PROJECT TITLE: ALL AMERICAN FOAM
OFFICE/WAREHOUSE COMPLEX ZONE ATLAS/DRNG. FILE #: L-20/D54

**RE: TEMPORARY ENGINEER CERTIFICATION FOR ALL AMERICAN
FOAM OFFICE/WAREHOUSE COMPLEX (L20-D54) CERTIFICATION
STATEMENT DATED 9/16/96.**

**RE: ALL AMERICAN FOAM OFFICE/WAREHOUSE COMPLEX (L20-D54)
DRAINAGE PLAN FOR FOUNDATION PERMIT APPROVAL. ENGINEER'S
STAMP DATED 9-29-95.**

FRANK D. LOVELADY, P.E. 300 ALAMOSA ROAD N.W. ALBUQUERQUE, N.M. 87107 (505) 345-2267			GRADING AND DRAINAGE PLAN OFFICE/WAREHOUSE COMPLEX FOR ALL-AMERICAN FOAM			SHEET OF /
Designed: F.D.L.	Drawn: STAFF	Checked: F.D.L.	Scale: 1" = 20'	Date: 9/95	Job No. 500

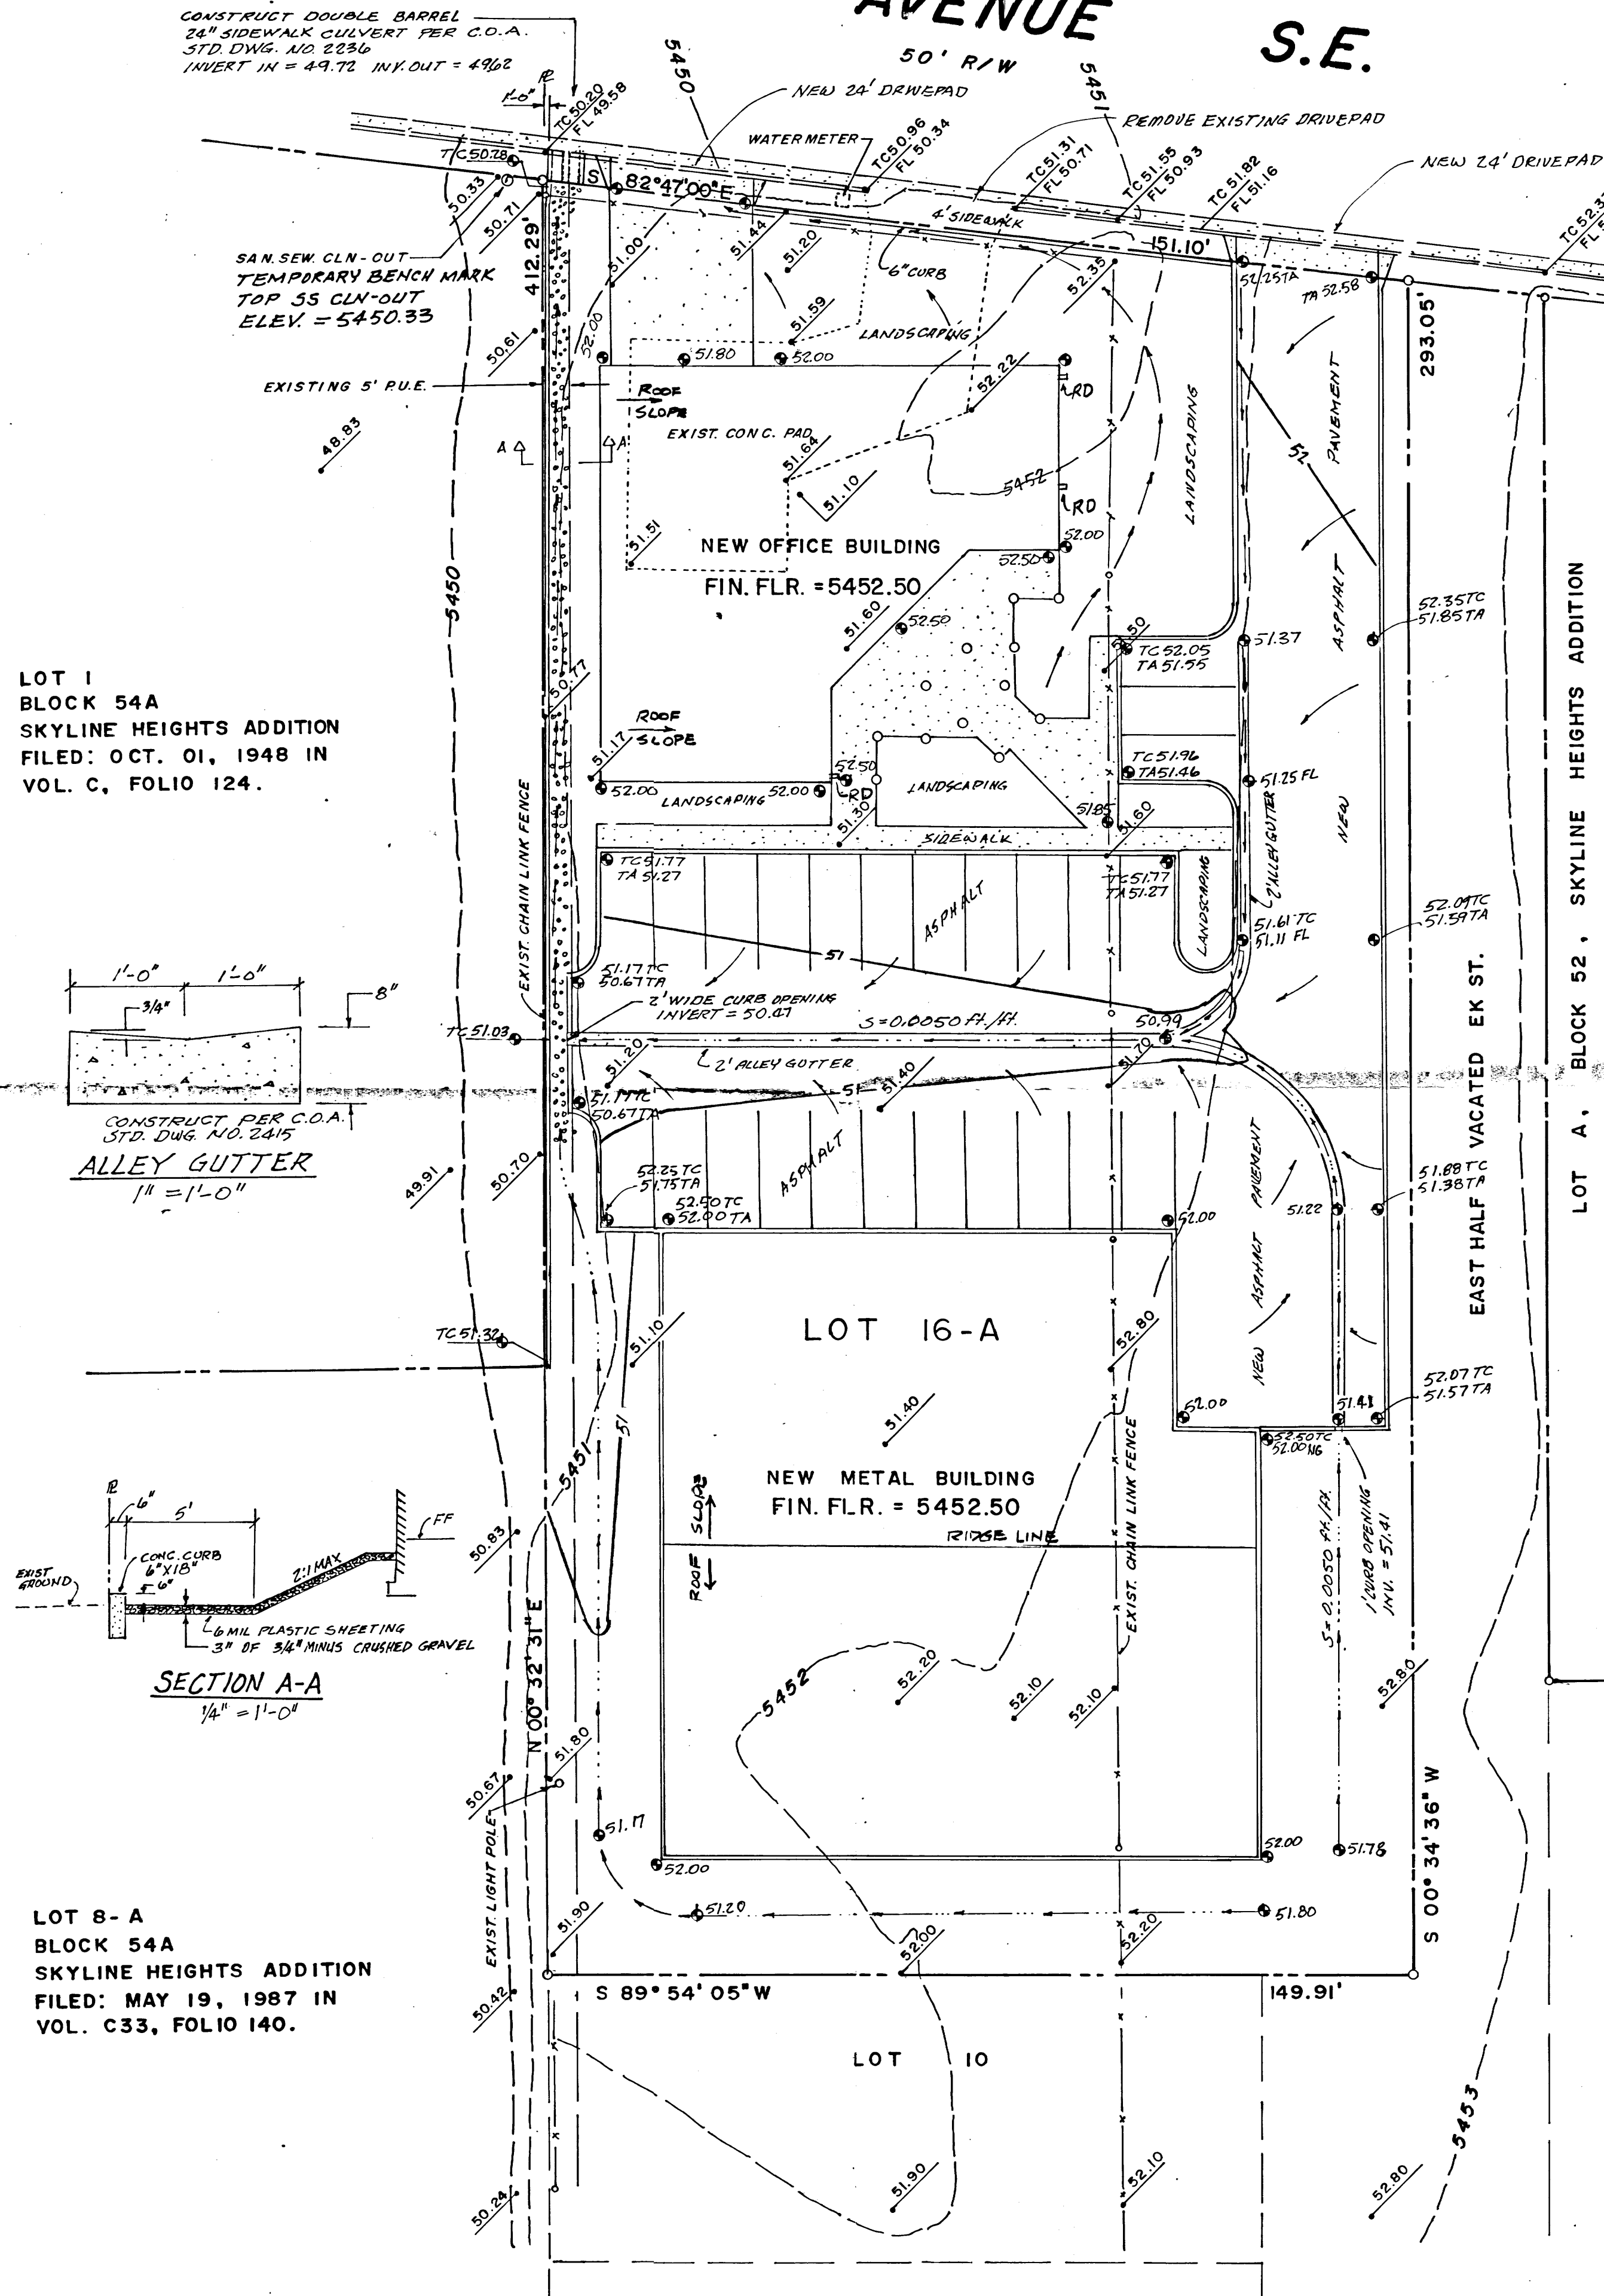
1. Under the PROPOSED CONDITIONS heading in your narrative, delete reference to ponding.
2. Under the PEAK DISCHARGE PER ACRE, EXCESS PRECIPITATION AND AREAS heading you state that the existing site is land treatment "A." It appears from your table that most of the existing Land treatment is "C" and a small amount of "D." Please clarify.
3. Please send two plan sheets with your next submittal, as I will need to forward a set for SO-19 approval.
